PLANNING AMENDMENT

H23/0911/02/11

2 Bedroom House.

Amendment: Reposition en-suite window (dwg no. 01-D)

Job Ref: 305-01	Drawing No: 01-D
Date: JULY '01	Drawn: J.C.

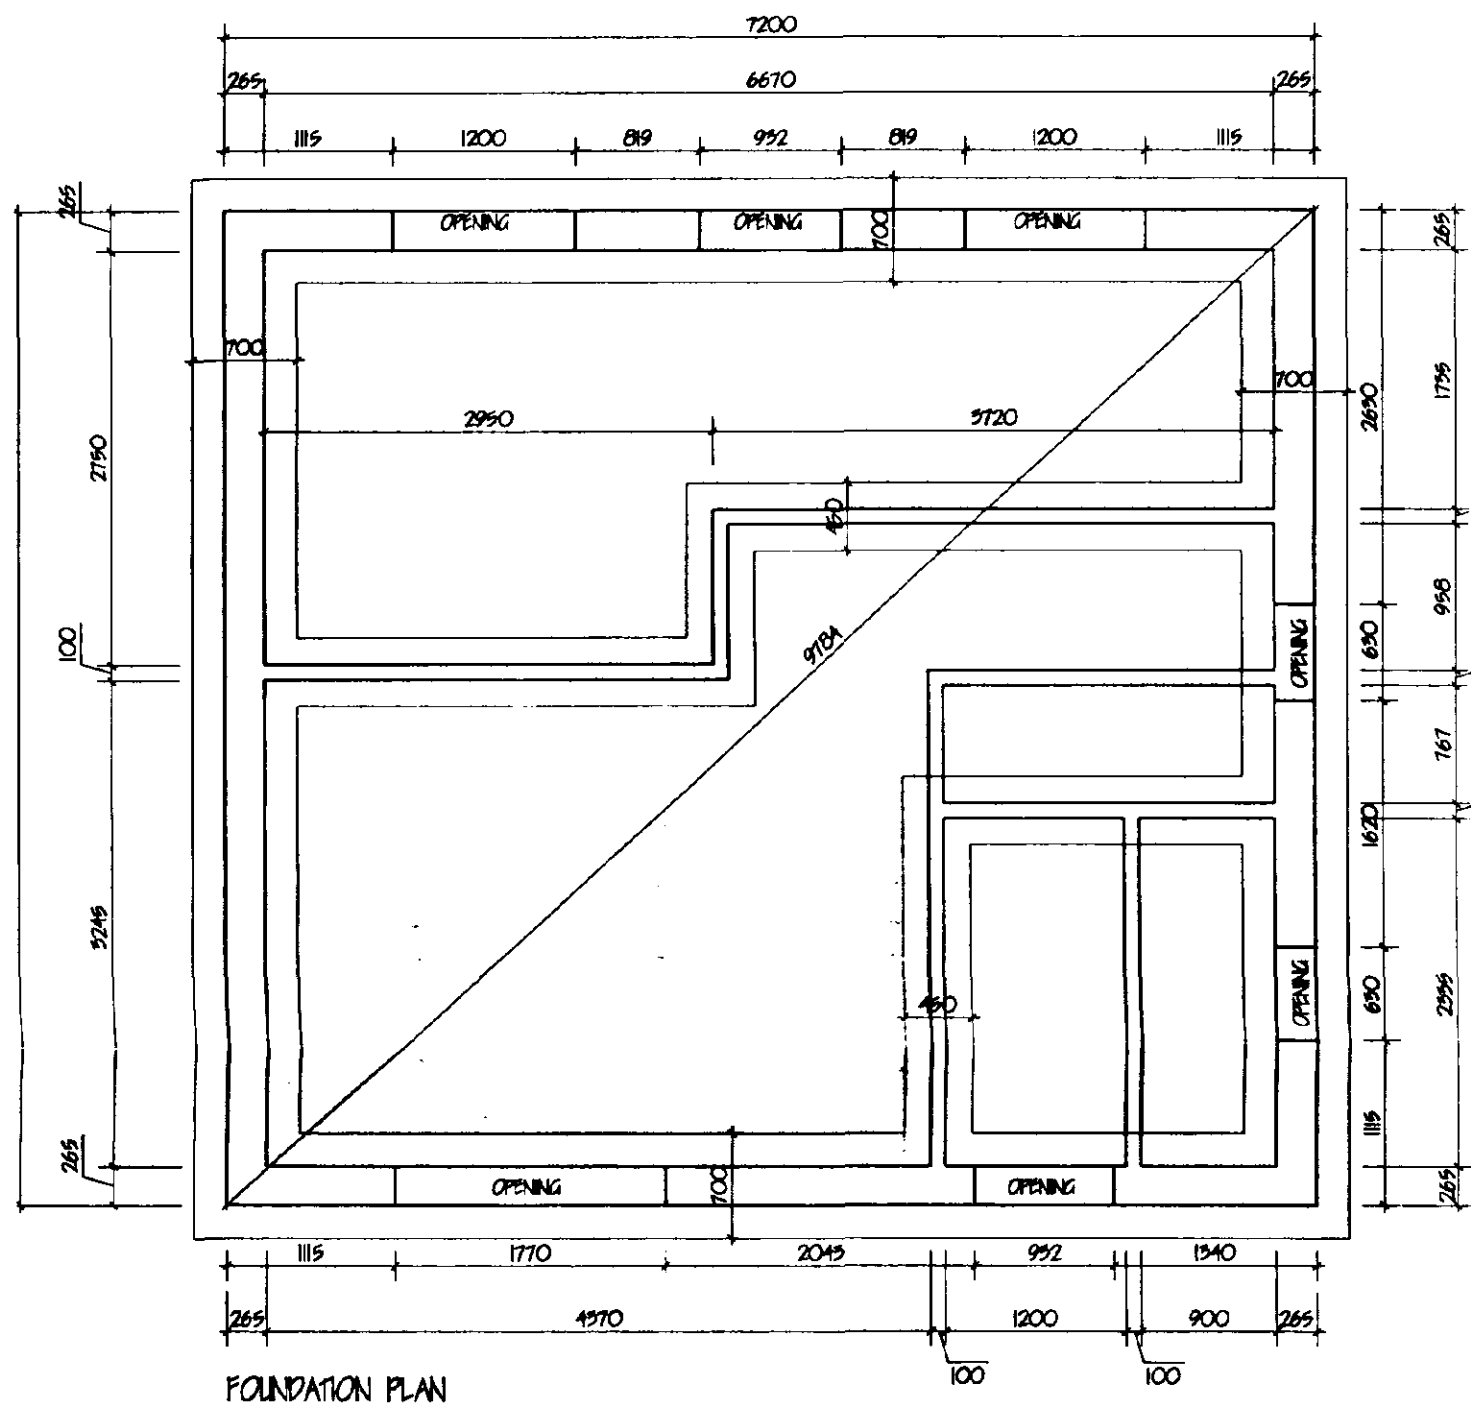
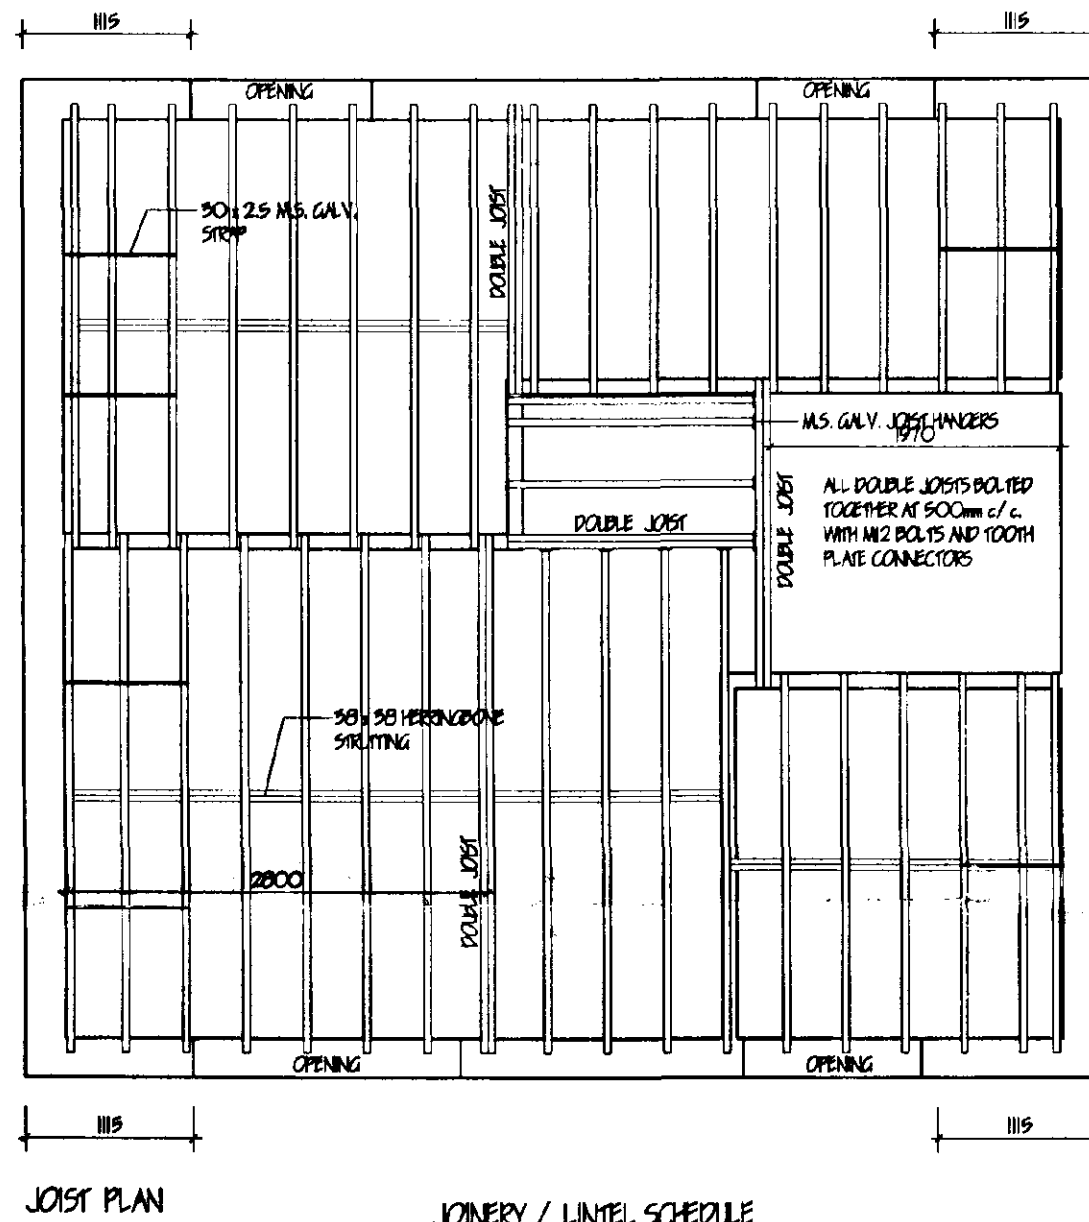
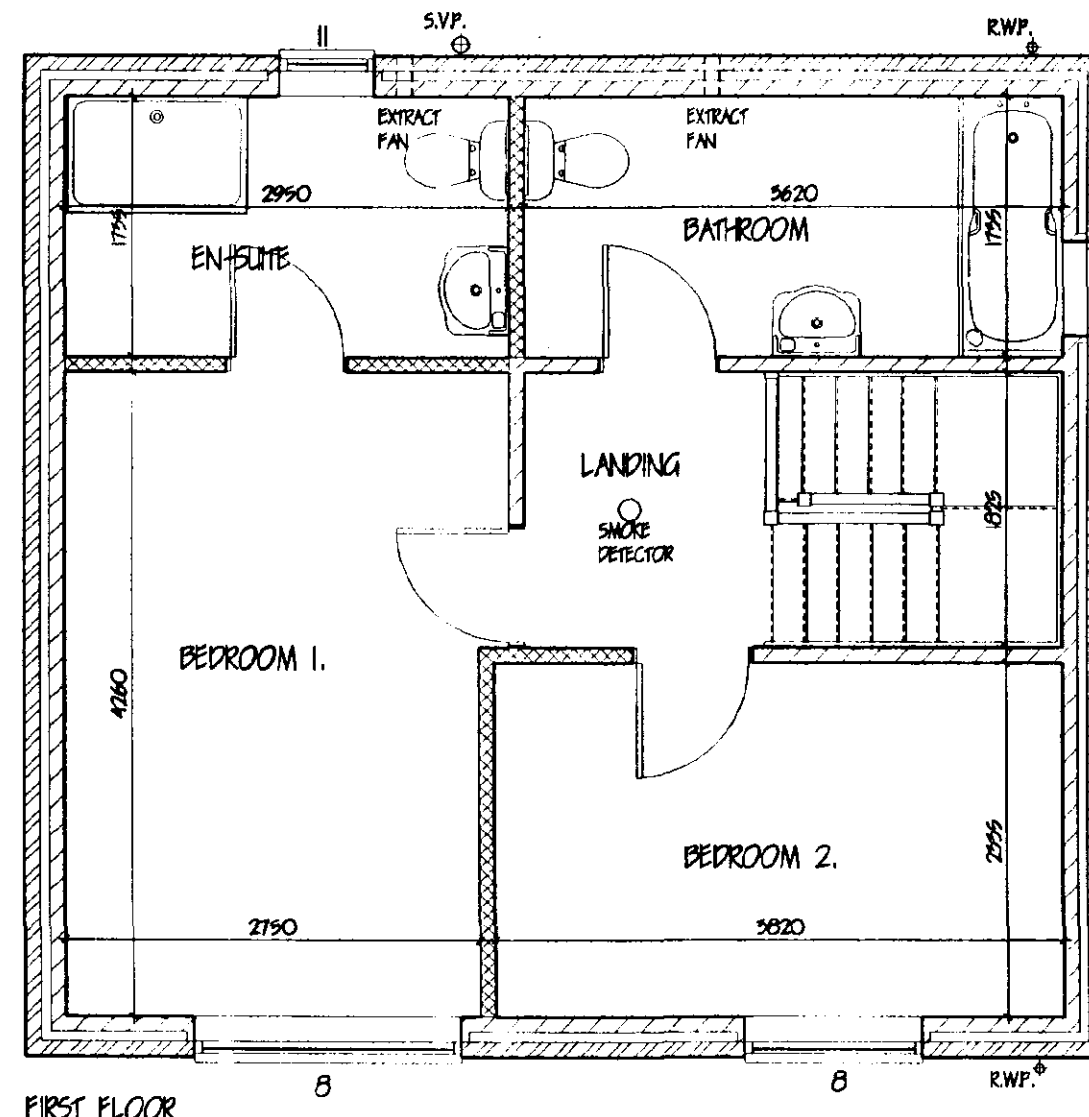
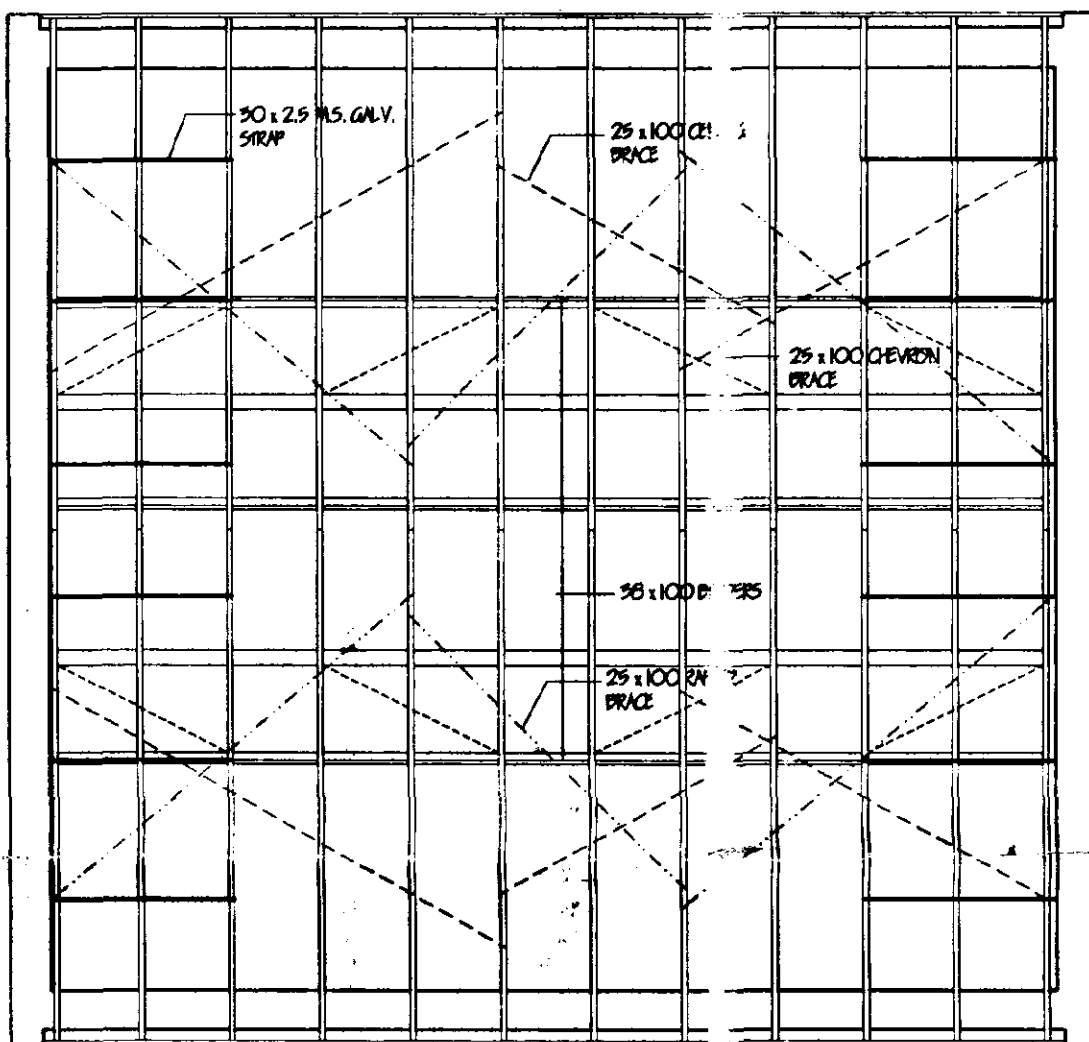
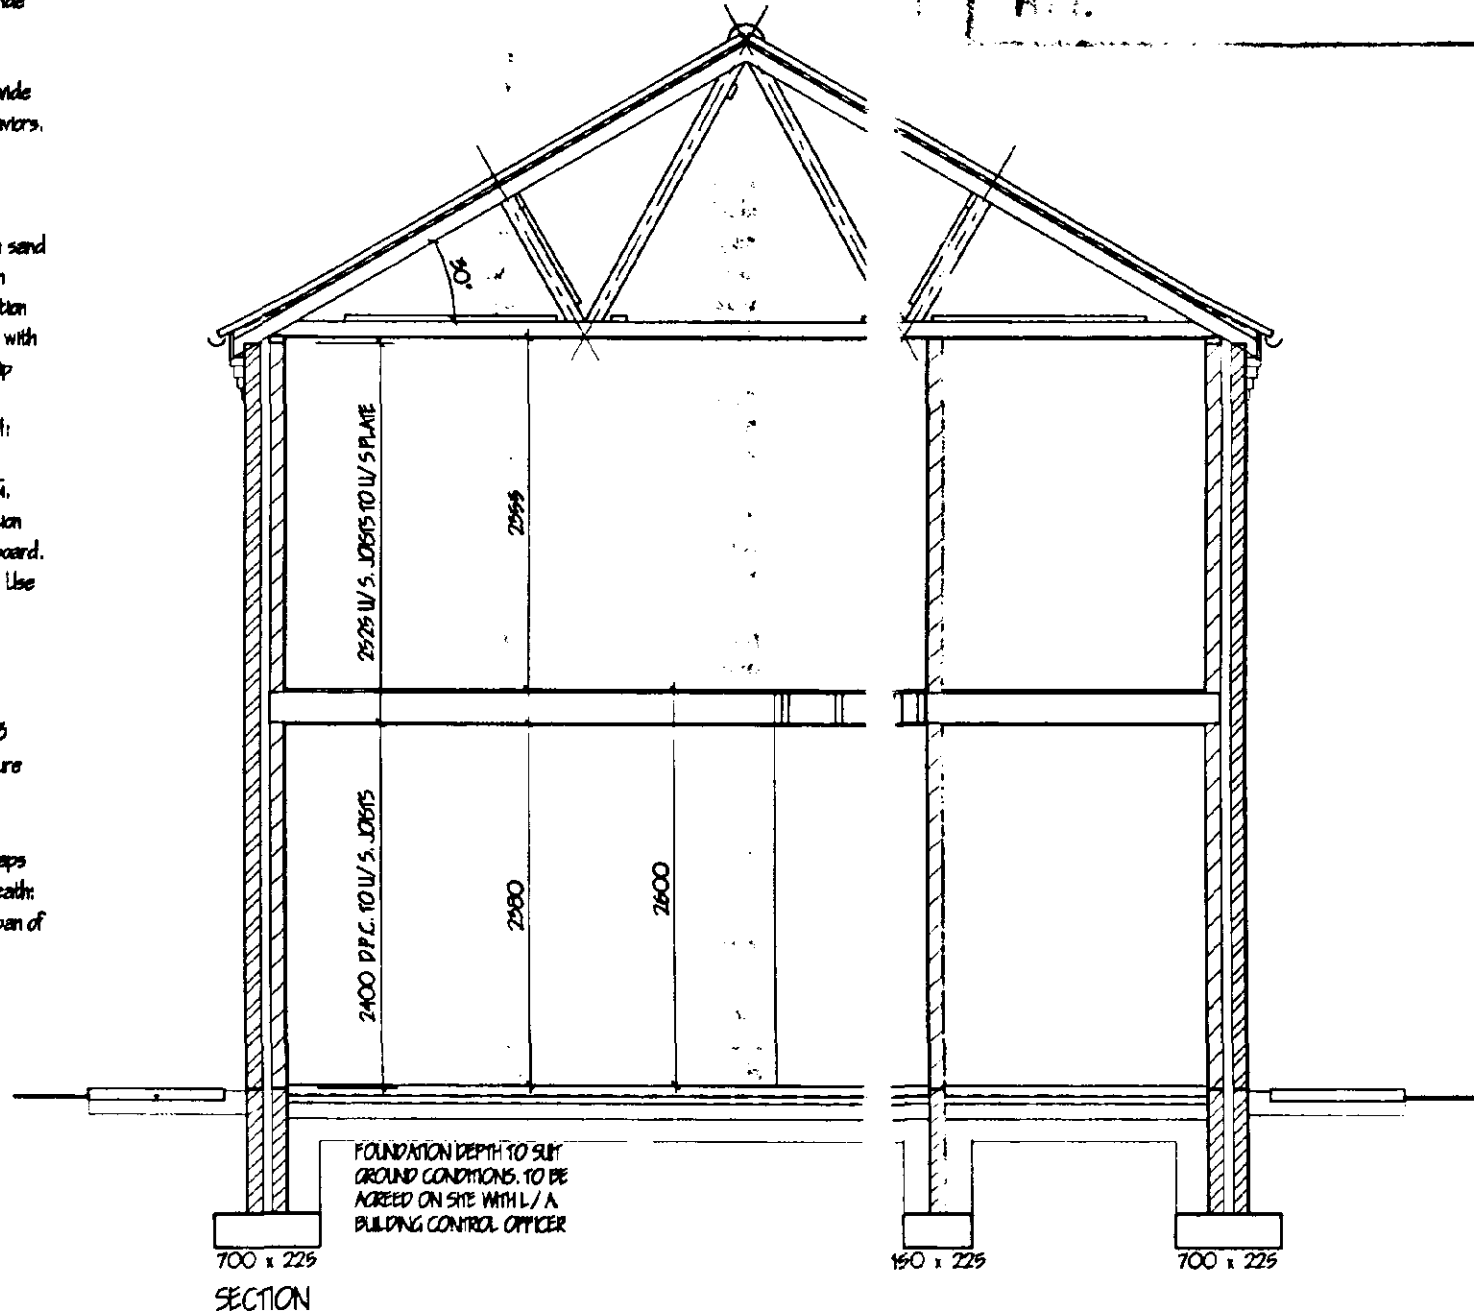
Re- location EN- SITE
INDENTED.

Reposition ensuite window side to rear.
